Lansdowne 2.0 - Event Centre

Response to Comments

Site Plan Control (D07-12-24-0082)

LANSDOWNE EVENT CENTRE
 DWG. TITLE: **LANDSCAPE LAYOUT PLAN**
 SCALE: 1:400
 DWG. NO.: L1.0
 PROJ. NO.: CSW #1766-12

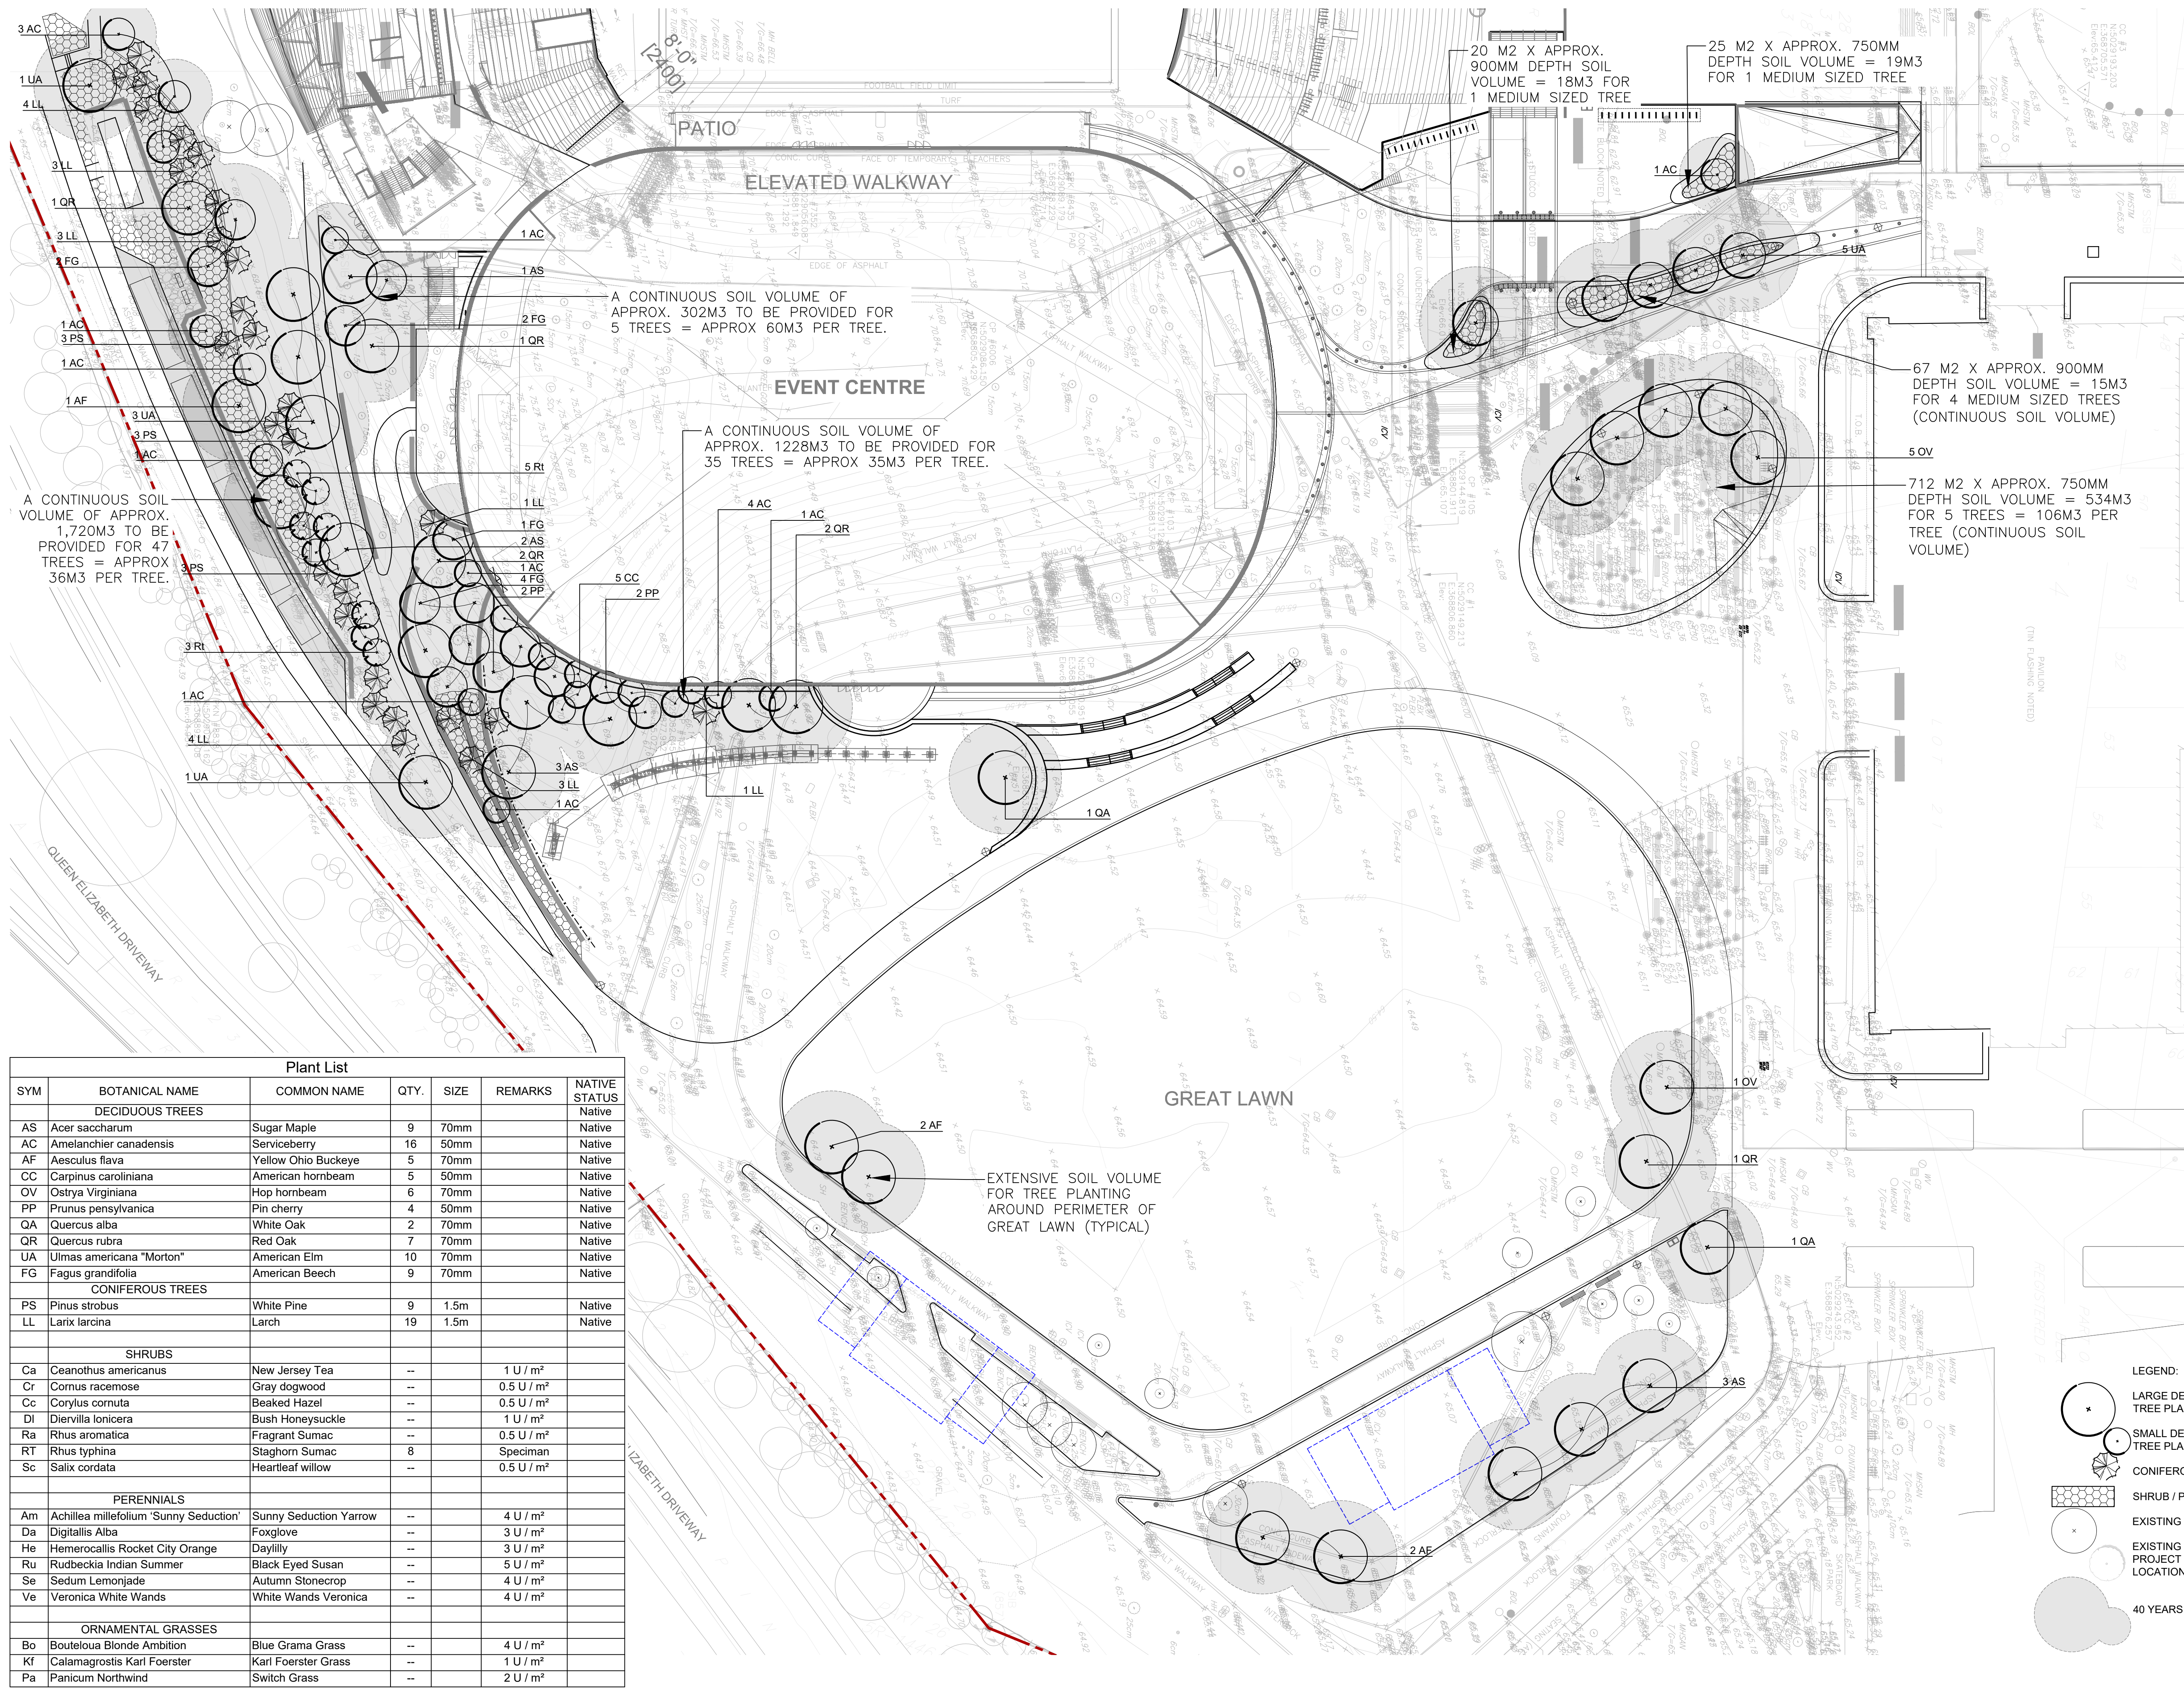
2.3	With respect to the landscape plan, we appreciate the geometrical changes to the "ellipse". Such changes are trending in the right direction in response to the context and the recommendations of the UDRP. We believe, however, further refinements to the geometry of the driveway surrounding the great lawn, for example, replacing the large curve with a few straight lines connected by short curves without compromising the proposed functions, can be helpful to create for more cohesive design. We acknowledge that design style is typically not an issue of urban design concern, but the development of Lansdowne Park has its own unique historical context (the award-winning plan).	CSW	We have reviewed as a team and feel the larger curve allows us to maximise the area of the great lawn as desired by both the local community and the City for hosting large events. It also complements the curvilinear shapes of the new event centre and berm while opening up views to the South facade of the historic Aberdeen Pavillion.

6.0	Active Transportation		
	Landscape Layout Plan, Drawing EC-L1.0, dated 15 Jan 2025		
6.44	Comment Response 4.140 states "...the vehicular access route has been reduced to 7.0m" in reference to the "pinch-point" location at the SW corner of the Aberdeen Pavillion, however drawing EC-L1.0 (cross referenced with EC-A1-004) shows a 7.6m vehicle access route and a 7.0m pedestrian route.	CSW	The seating wall (landscape island) was pulled back from a previous version, at the request of RCFS, to open up this area further to pedestrians. Removable bollards and planters are shown, at the request of RCFS, to ensure delineation of space but allowing pedestrians to move through to the full 14.6m width of the throat entrance to/from the Great Lawn. The landscaping treatment of the 14.6m wide entrance is intentionally uniform to ensure that the entire width is perceived as a pedestrian zone that is accessible and inviting to people walking through the space on non-event days and event days. The position of the removable bollards have been adjusted to allow equal division of the space between the AODA access route and pedestrian entrance from Exhibition Way. This spacing allows for larger crowd volumes leaving Gate 4 from a major event, such as a REDBLACKS game to use the flex AODA area (knowing the path of least resistance is where pedestrians will naturally flow). 7.3 metres allows for emergency vehicles to manoeuvre safely through the area (two ambulances passing or two AODA vehicles passing). This includes additional buffer space for emergency vehicles while AODA vehicles are staged on the pick-up area. Pedestrians have more space in the proposed arrangement than in the existing condition (through adjusted location of existing ramp). In the future the bollards/planters can be assessed, and a determination can be made by RCFS if they are warranted to remain - or removed in the future.

SCALE AS SHOWN DWG. NO. L3.1
PROJ. NO. CSW #1766-12

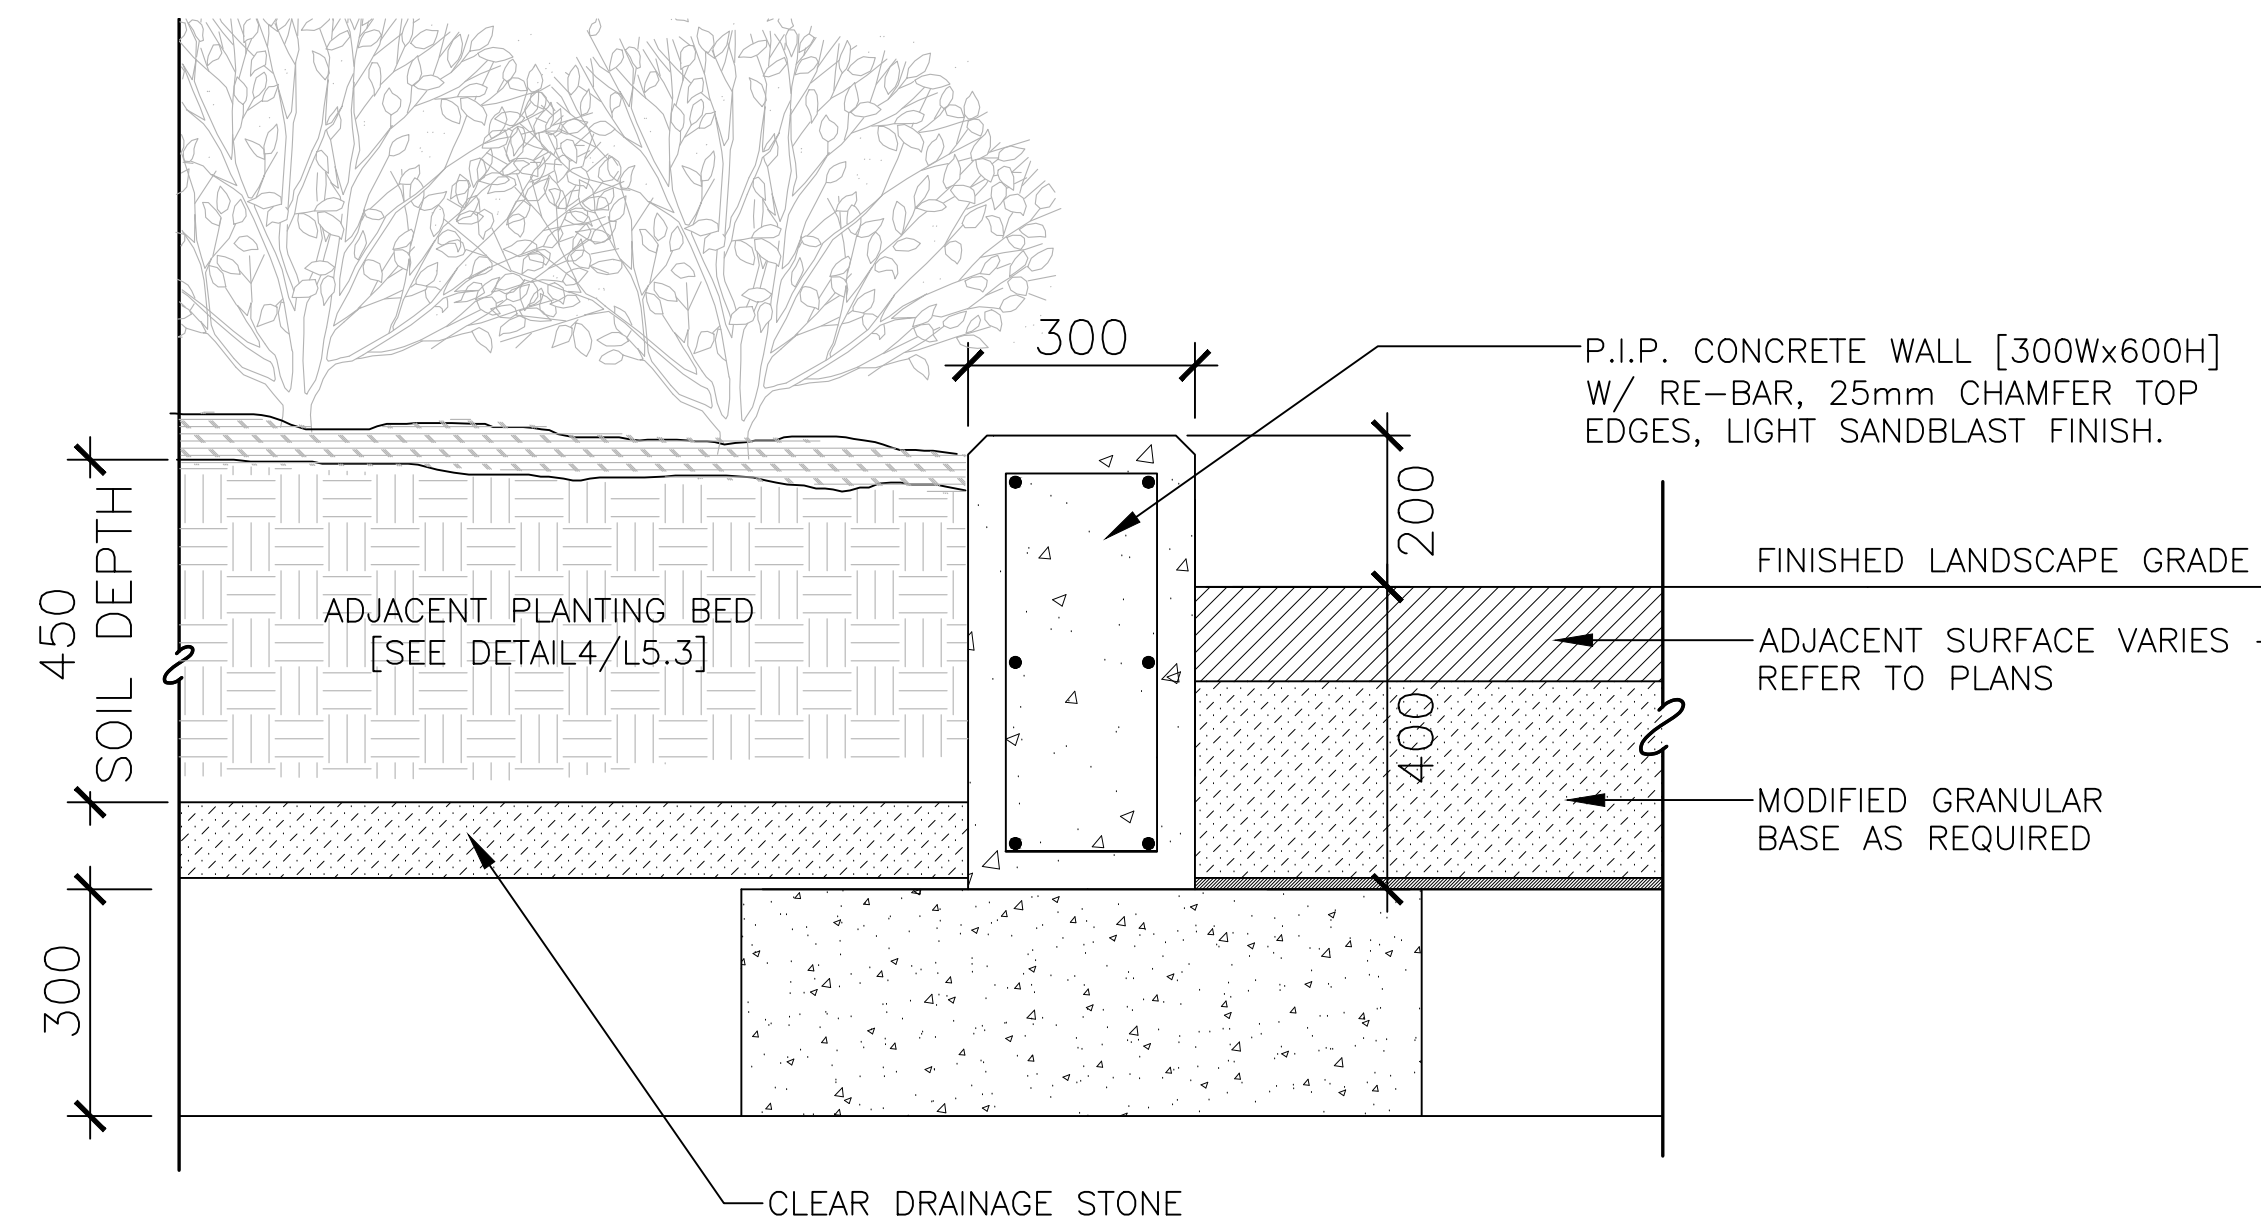
3.10	As per section 6.9 Landscaping Considerations (Retaining Walls): "It is recommended that a 100 mm diameter perforated corrugated plastic pipe with geosock, surrounded by 150 mm of 19 mm clear crushed stone on all sides, be placed behind the heel of the wall. The pipe should have a positive outlet, either in front of, below, or to the side of the wall, towards a natural slope or drainage system. This recommendation shall be accounted for in the Landscaping Plans (Rev. 03 -Issued for City SPA Comments dated 5 SEP 2024). Please clearly detail the recommended subdrain system in all applicable retaining wall and planet wall details on L3.1 and L3.2 respectively. Paterson Response: Acknowledged, refer to updated drawings. (Details will be further developed through construction documentation). City Response: Armour stone wall details do not show the 100mm perforated drainage pipe, please update the landscaping drawings accordingly. Please see City of Ottawa standard detail drawing L7 for minimum detail requirements.	CSW	Landscape drawings have been updated. Please note some details have been renumbered as the design development has progressed. Refer to detail 2A/3.2 (planter walls) and detail 5/L3.3 (armour stone walls) for typical details. For armour stone walls less than 1.0m in height (detail 9/L3.1) we do not believe the perforated pipe is a requirement.

No.	Comment	Responsibility	
3.36	As per section 6.9 Landscaping Considerations (Retaining Walls): "It is recommended that a 100 mm diameter perforated corrugated plastic pipe with geosock, surrounded by 150 mm of 19 mm clear crushed stone on all sides, be placed behind the heel of the wall. The pipe should have a positive outlet, either in front of, below, or to the side of the wall, towards a natural slope or drainage system. This recommendation shall be accounted for in the Landscaping Plans (Rev. 03 -Issued for City SPA Comments dated 5 SEP 2024). Please clearly detail the recommended subdrain system in all applicable retaining wall and planet wall details on L3.1 and L3.2 respectively. Paterson Response: Acknowledged, refer to updated drawings. (Details will be further developed through construction documentation). City Response: Armour stone wall details do not show the 100mm perforated drainage pipe, please update the landscaping drawings accordingly. Please see City of Ottawa standard detail drawing L7 for minimum detail requirements.	CSW	Refer to 3.10 above
